Project Name:	Pre-owned Automobile Dealership	Project ID:	#2016-189
Address:	783 Forest Avenue	CBL:	137-C-001
Applicant:	Stephen E Mardigan		
Planner:	Jean Fraser

TO: Jean Fraser, Planner
FROM: Lauren Sweet, PE & Craig Sweet, EIT
DATE: September 7, 2016
RE: 783 Forest Avenue, Level I Site Plan Application

Woodard & Curran has reviewed the Site Plan Application for the proposed site is located at 783 Forest Avenue in Portland, Maine. The project involves the construction of planter beds, new pavement striping, repair of sidewalks, driveway aprons and installation of new curbing.

DETAIL 2
3 OF 3

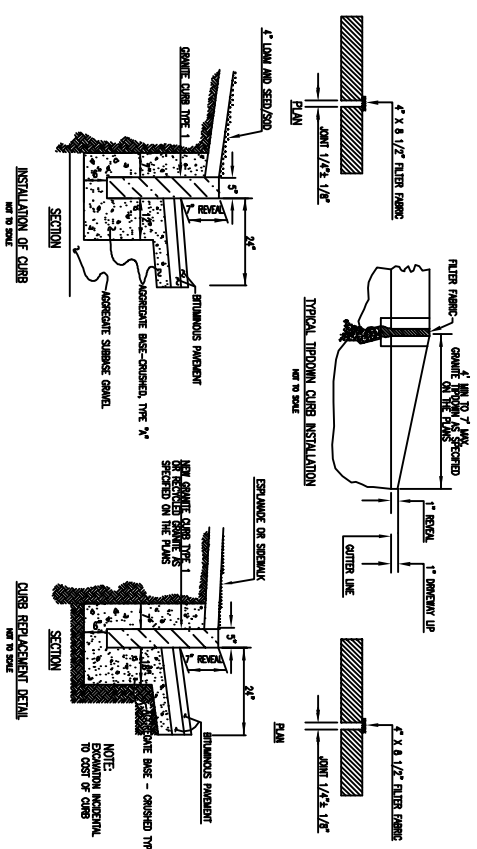
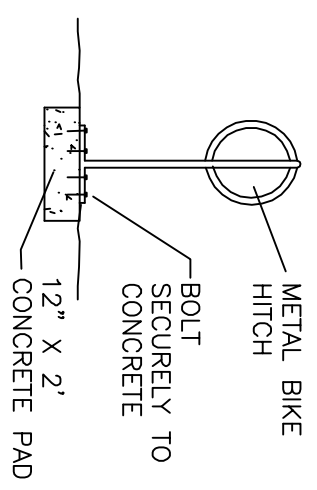
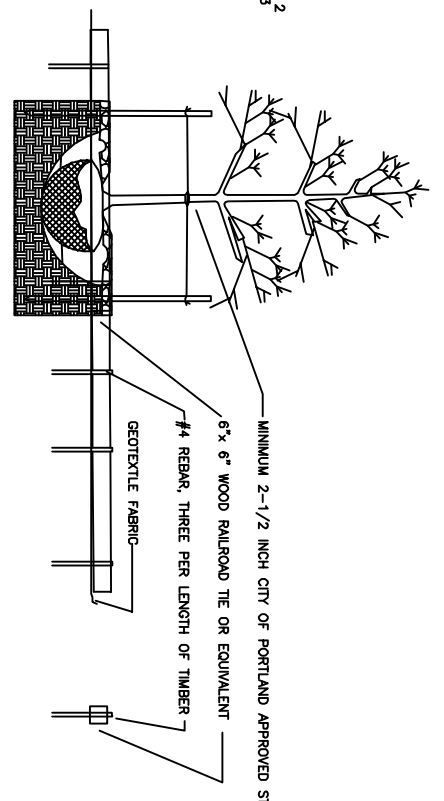
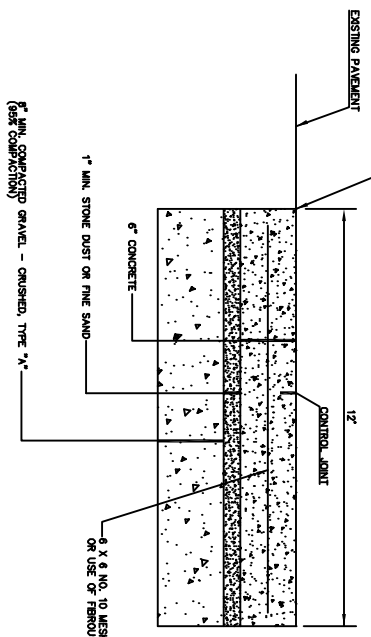
2. The following details provided should be in conformance with the City of Portland Technical Design Manual. The manual with standard details is available here:
<http://me-portland.civicplus.com/757/Technical-Design-Standards>

- a. Driveway apron - update the detail to be in conformance with City of Portland standards (see comment below on material type). The driveway aprons shall be constructed to meet ADA standards to the extent practicable, achieving a maximum 2% cross-slope for a minimum of 3' of the sidewalk width along the back of the 5' wide sidewalk. The sidewalks shall be constructed to have a maximum 2% cross-slope.

- b. Concrete sidewalk – update detail to be in conformance with City of Portland standards, including a note that that minimum cross slopes shall be 2%.

SEE SHEET
C3-DETAIL SHEET
FOR SPECIFIED
CONSTRUCTION
REQUIREMENTS.

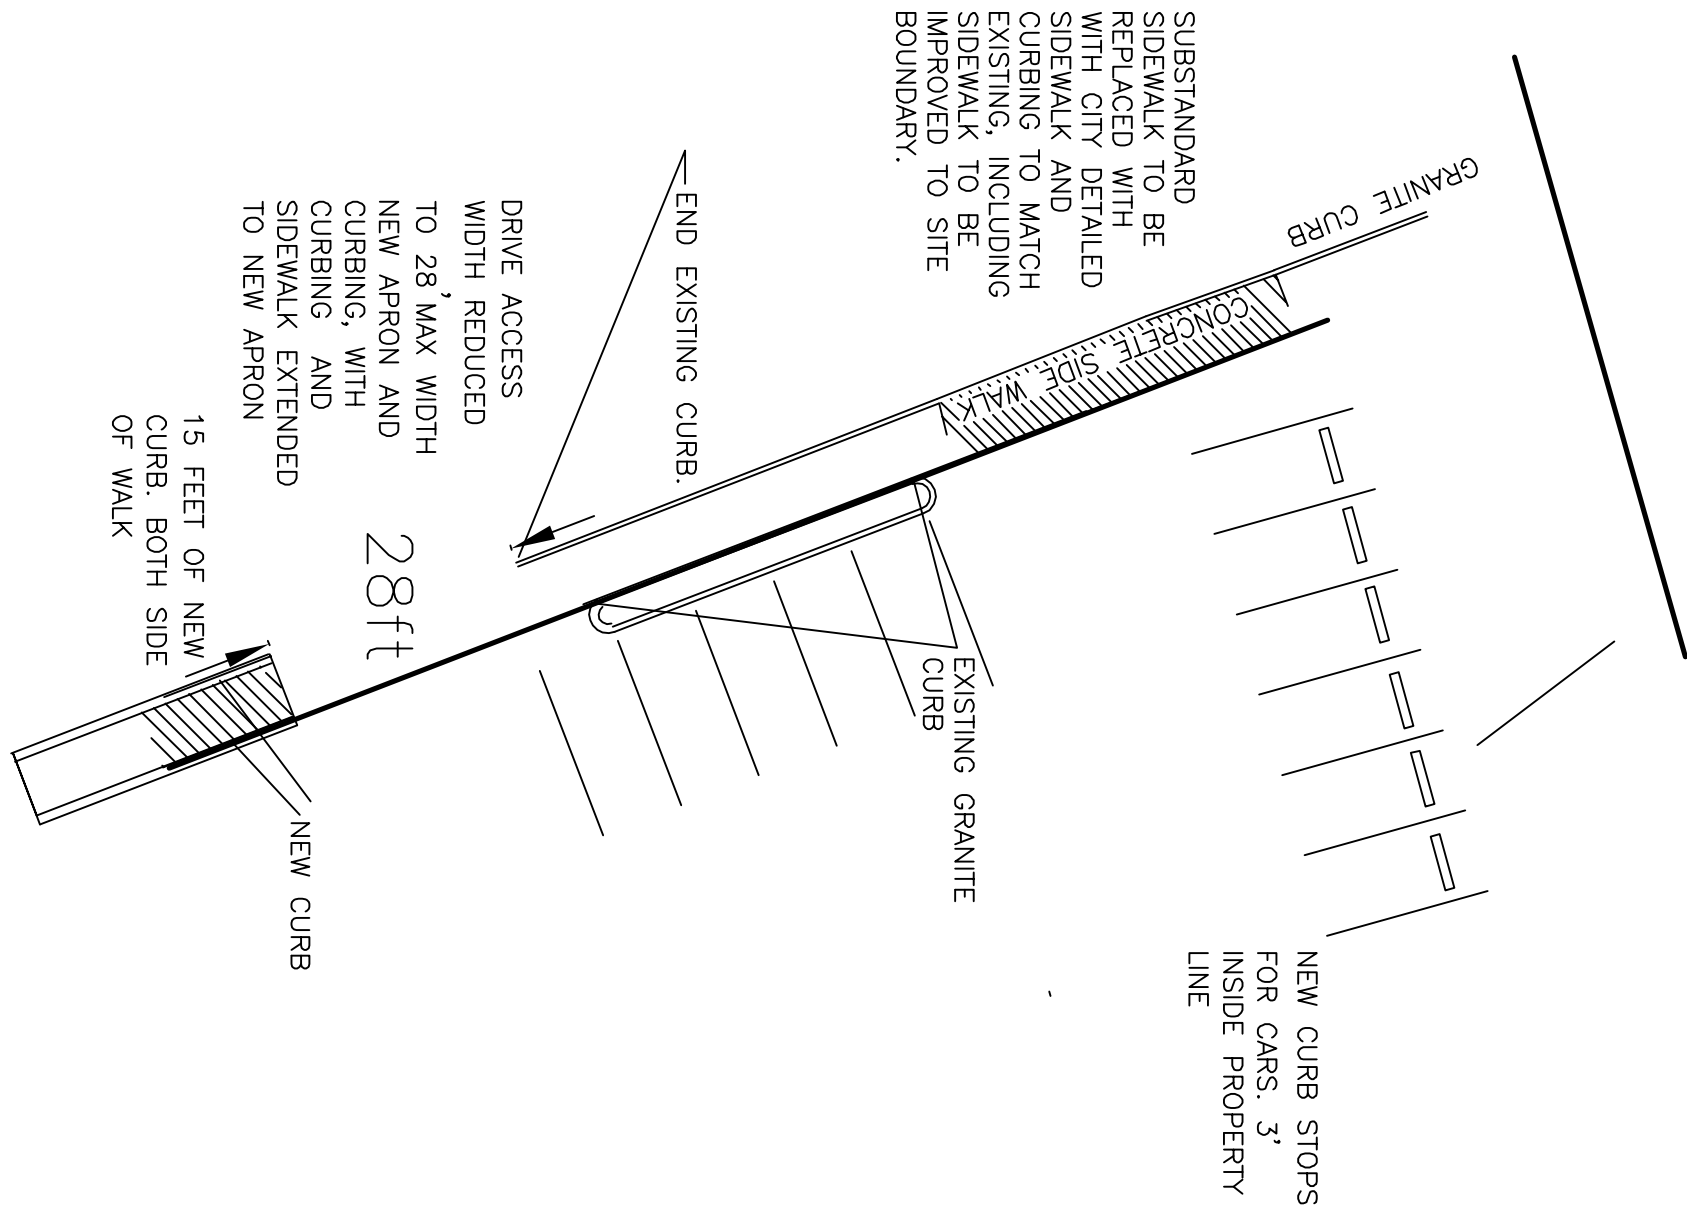
1. The plans should show or note catch basin inlet protection (silt sacks) to be installed at the first down-gradient catch basin in Forest Ave during construction. The plans should state that the Forest Ave Right-of-Way shall be kept clean from dust and construction debris and swept daily or as requested by the City of Portland during construction to minimize dust and sediment originating from the site.

3. Notes should be provided to the plans indicating the following:
 - a. Obtain a Street Opening Permit by a licensed contractor before starting work.
 - b. A mandatory pre-construction meeting with City staff from the Planning and Public Works Departments shall take place on site after issuance of the Street Opening Permit and prior to starting work.
